CITY OF PORTLAND BUILDING PERMIT

PERMIT ID: 2012-65705

has permission to **Tenant Improvements to the 9th floor offices - "Strategic Media"**
provided that the person or persons, firm or corporation accepting this permit shall comply with all of the provisions of the Statutes of Maine and of the Ordinances of the City of Portland regulating the construction, maintenance and use of the buildings and structures, and of the application on file in the department.

Paul, Please find attached the corrected plan, drawing A1.0 and A1.2, for the Strategic Media tenant at 511 Congress Street in Portland. I have corrected the Key for the Wall Type at the Exit Access Corridor. In Accordance with the IBC 2009, Section 1018, Table 1018.1, the fire-resistance rating of the Exist Access Corridor for Business Use is required to be 0 hours for a building equipped throughout with an automatic sprinkler system.

**A1.0**

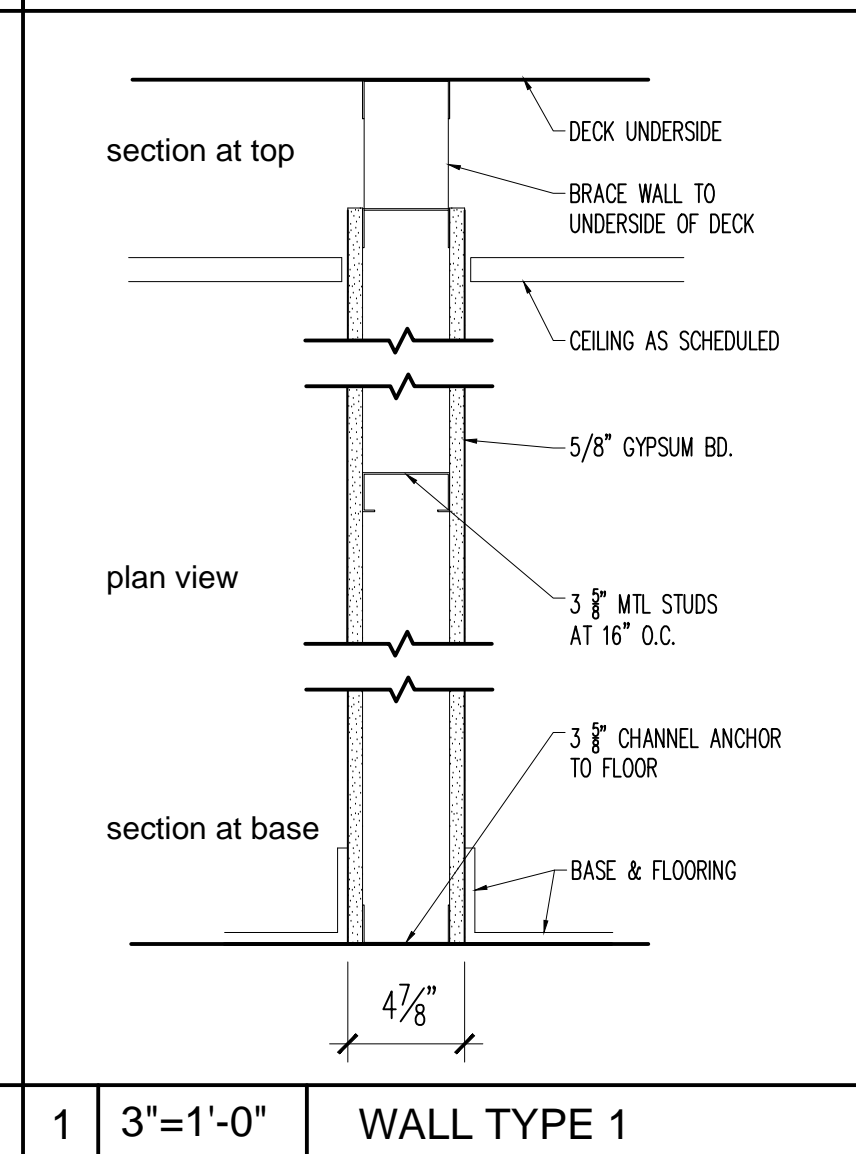
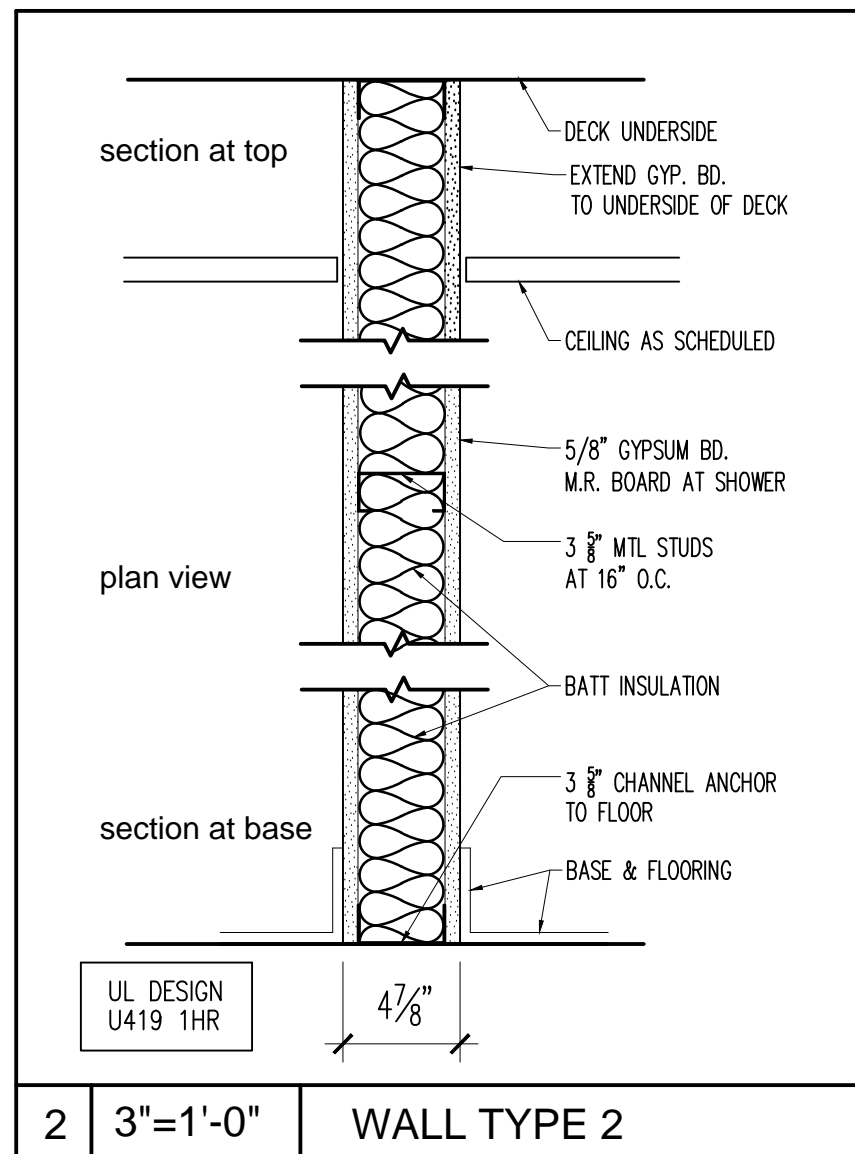
2-6-13 DWM/BKL Close-in Provide revised plans, 1 hr walls,
plumbing test.
